**From:** Carmichael Ian [mailto:ian.Carmichael@thamesvalley.pnn.police.uk]  
**Sent:** 19 July 2019 14:10  
**To:** Samantha Taylor  
**Cc:** Planning  
**Subject:** Planning ref: 19/01047/OUT. Land North East of Oxford Rd West of Oxford Canal and East of Bankside Banbury.

**Planning ref: 19/01047/OUT. Land North East of Oxford Rd West of Oxford Canal and East of Bankside Banbury.**

Figure 9:
Indicative Street Hierarchy

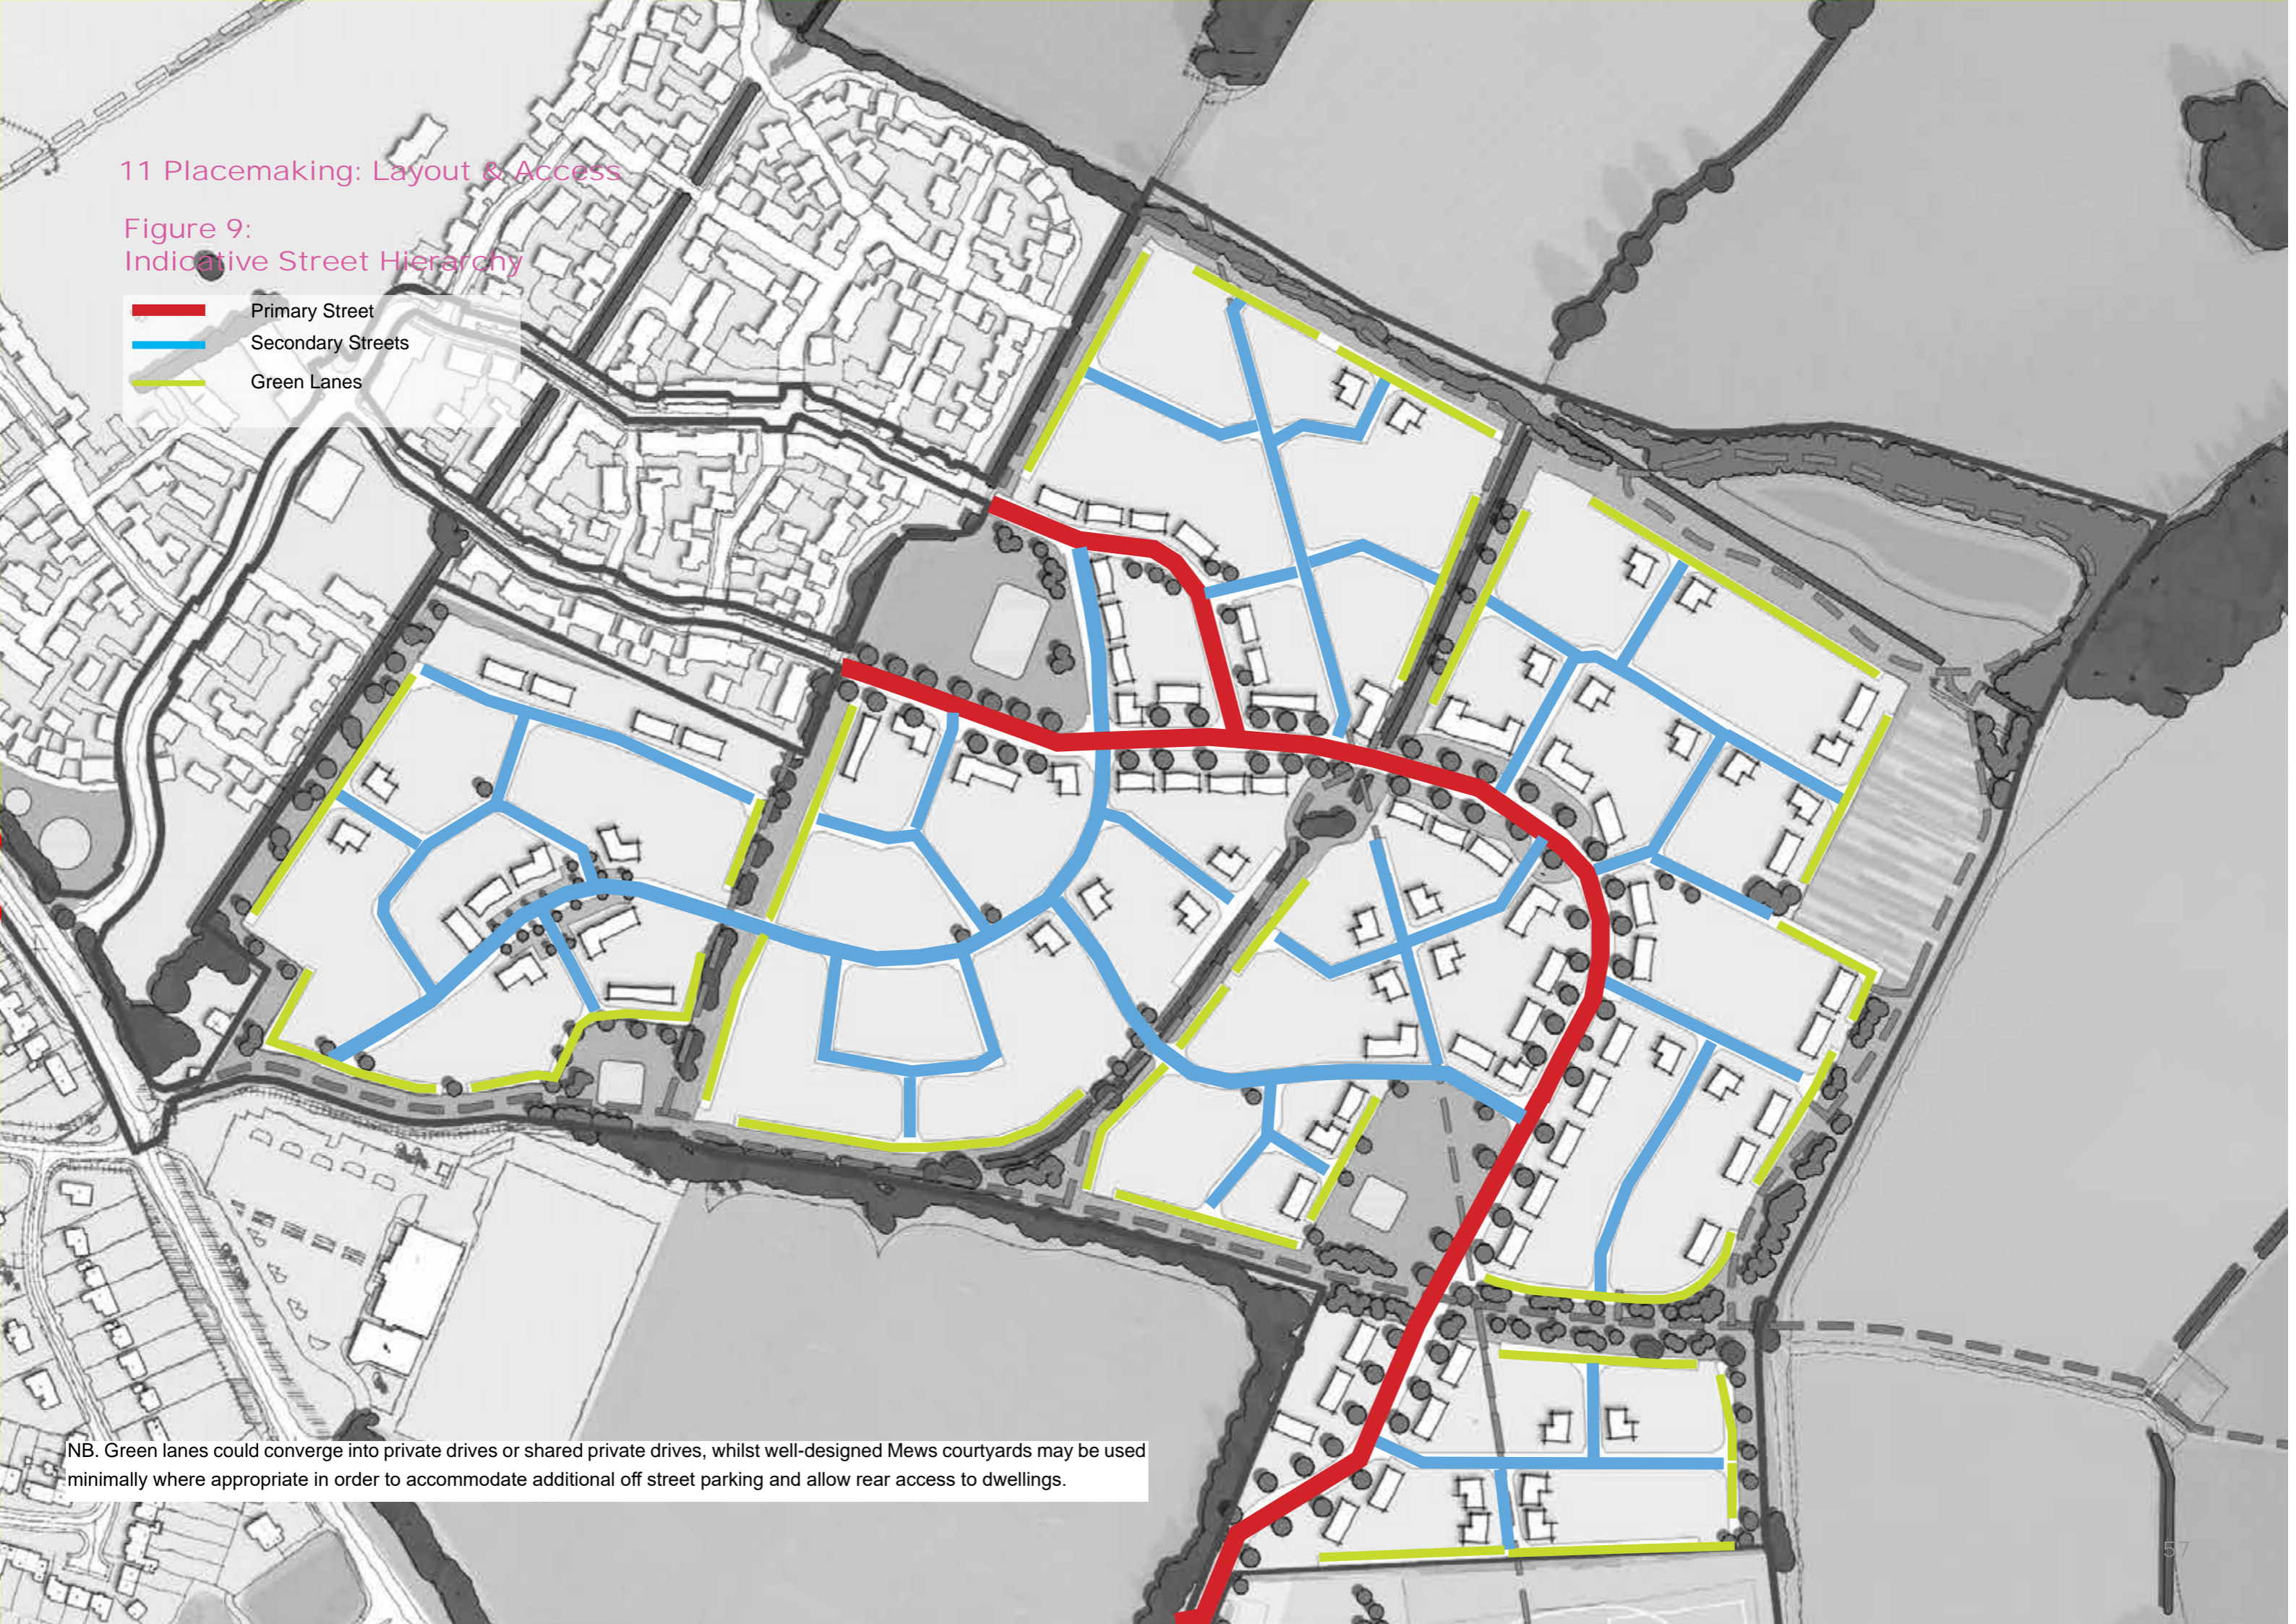
- Permeability is frequently mentioned throughout the DAS as a desirable quality within development. Although this is true, inappropriately high levels of permeability are likely to attract crime/anti-social behaviour (ASB), aid criminal search behaviour and provide escape routes for offenders. All routes should lead directly to where people want to go, serve a defined purpose and follow SBD guidance on their design. Permeability for permeability's sake should be avoided.

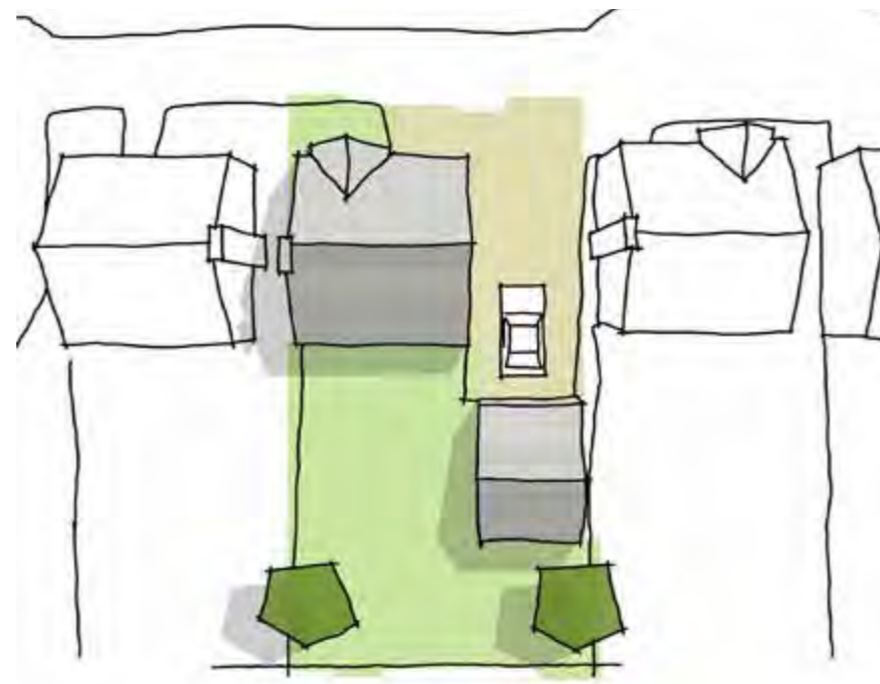
- Parking courts are proposed as part of the parking strategy for the development. Although I appreciate they may be necessary to serve flats etc. it should be recognised that these features make vehicles and the rear of properties vulnerable. They also often attract ASB. The intention is to reduce the impact of vehicles on the street, but in reality courts are frequently abandoned by residents in favour of parking in front of dwellings. This can lead to neighbour conflicts, parking on footways and access problems for all, including emergency services. They should only be used where absolutely necessary. Where they must remain, the number and size should be kept to a minimum and they should be made as secure as possible. Again, SBD provides guidance on how to achieve this.

Figure11: Landscape Strategy Schematic

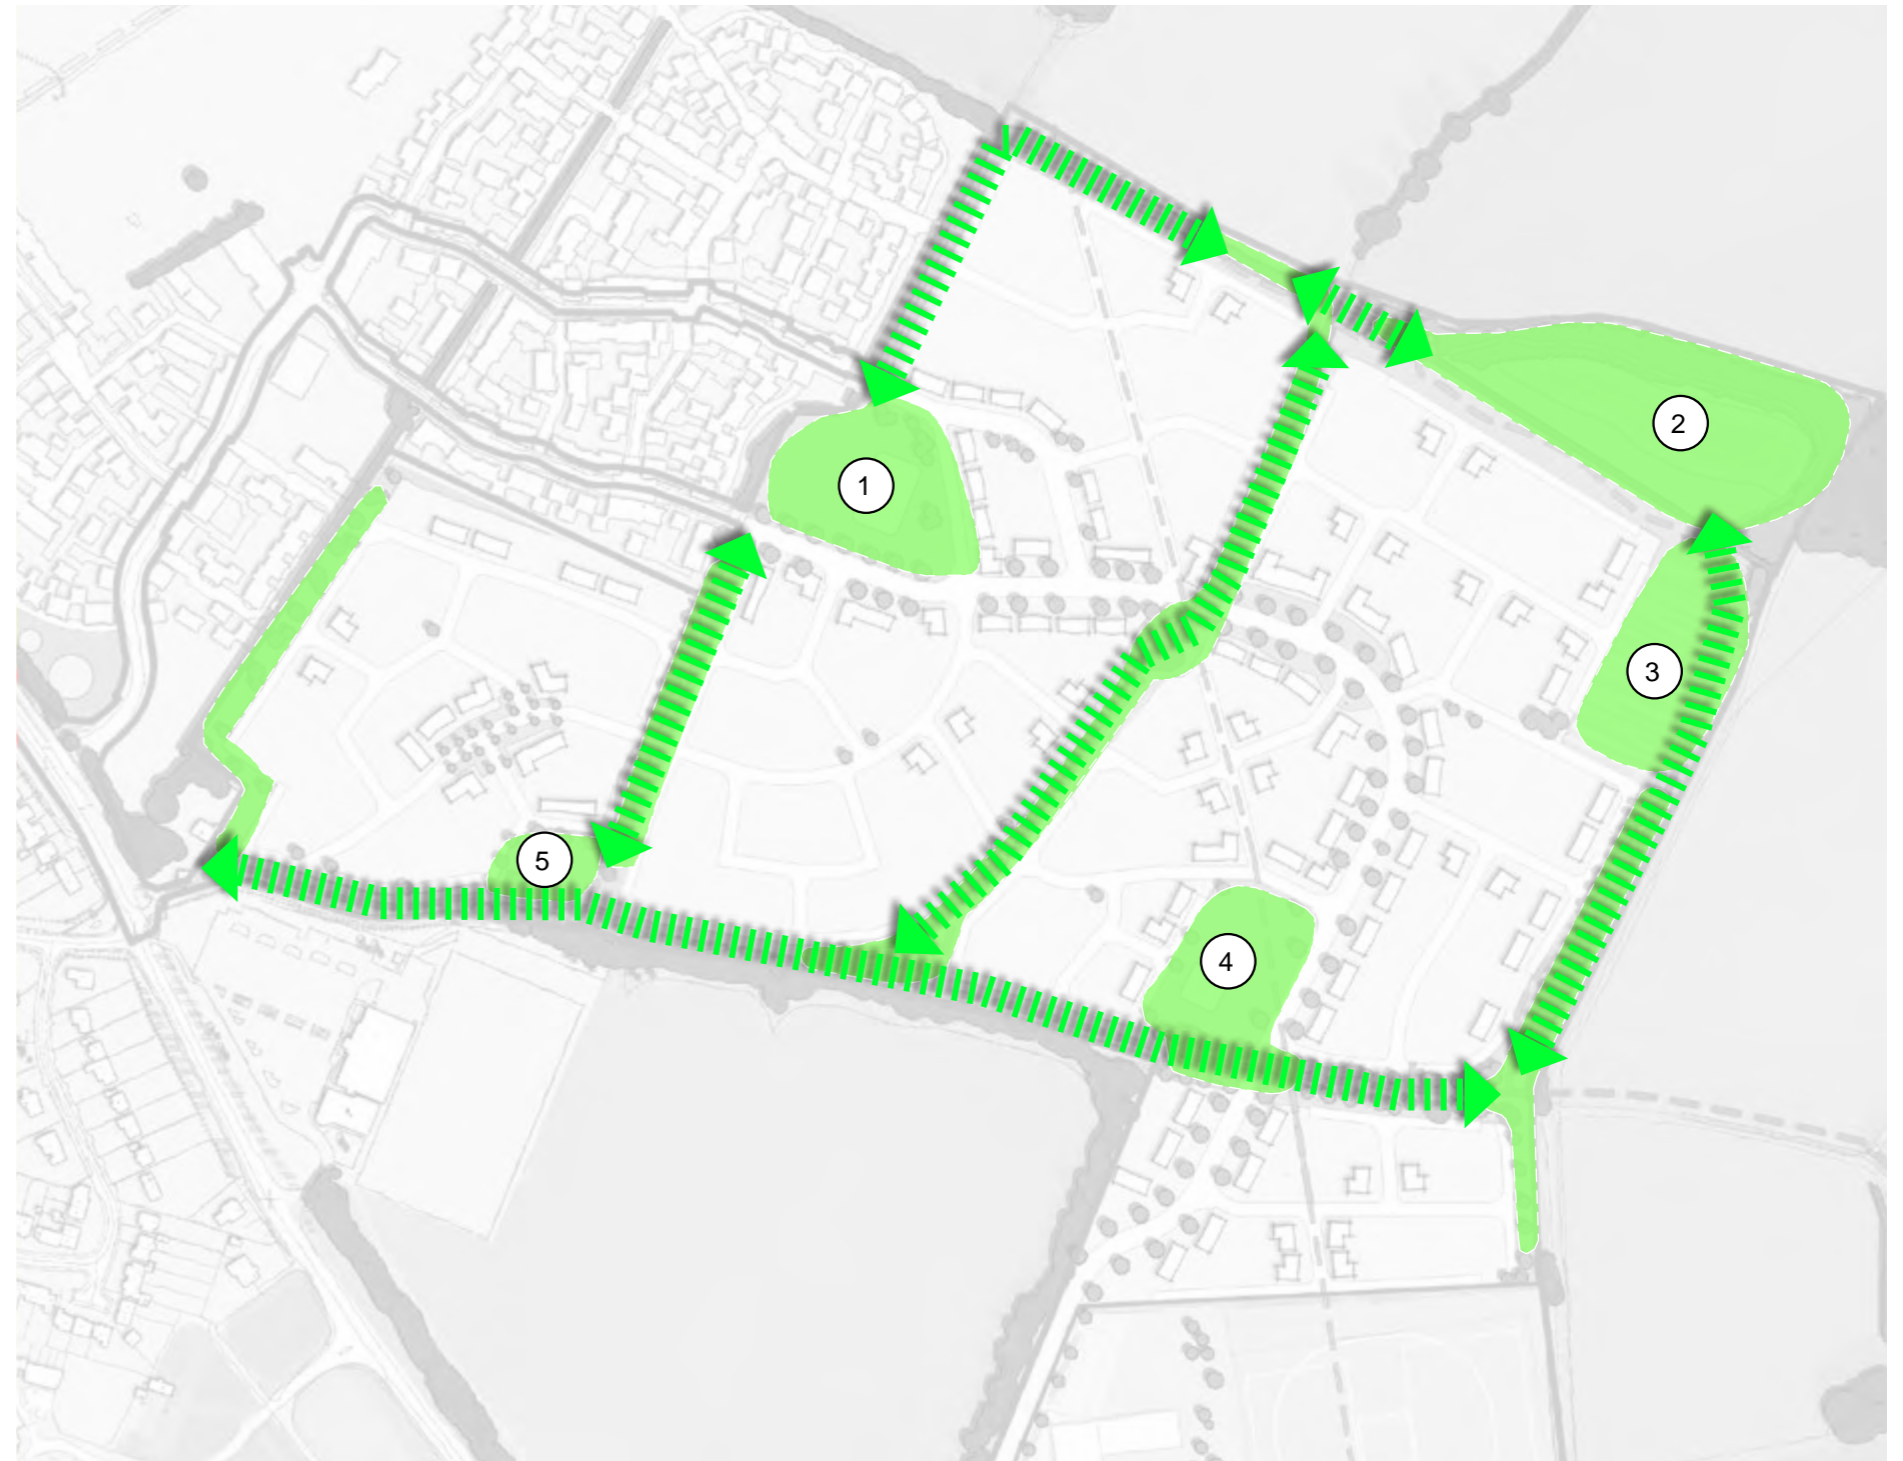
- The landscaping scheme should ensure that natural surveillance throughout the development and to/from dwellings is not compromised. Where appropriate, shrubs and hedges should have a final growth height of no more than 1m and tree canopies should encroach no lower than 2m so that an open aspect is maintained. In addition, a holistic approach should be taken in relation to landscape and lighting so the latter is not compromised. Tree positions and final growth height/spread should be considered to avoid this for the lifetime of the development.

- The detailed landscaping scheme and maintenance plan must ensure that areas of ambiguous ownership are not created. And, buffer strips adjacent to the existing and future housing will need special consideration in this respect to ensure they do not become hidden areas where ASB etc. takes place.
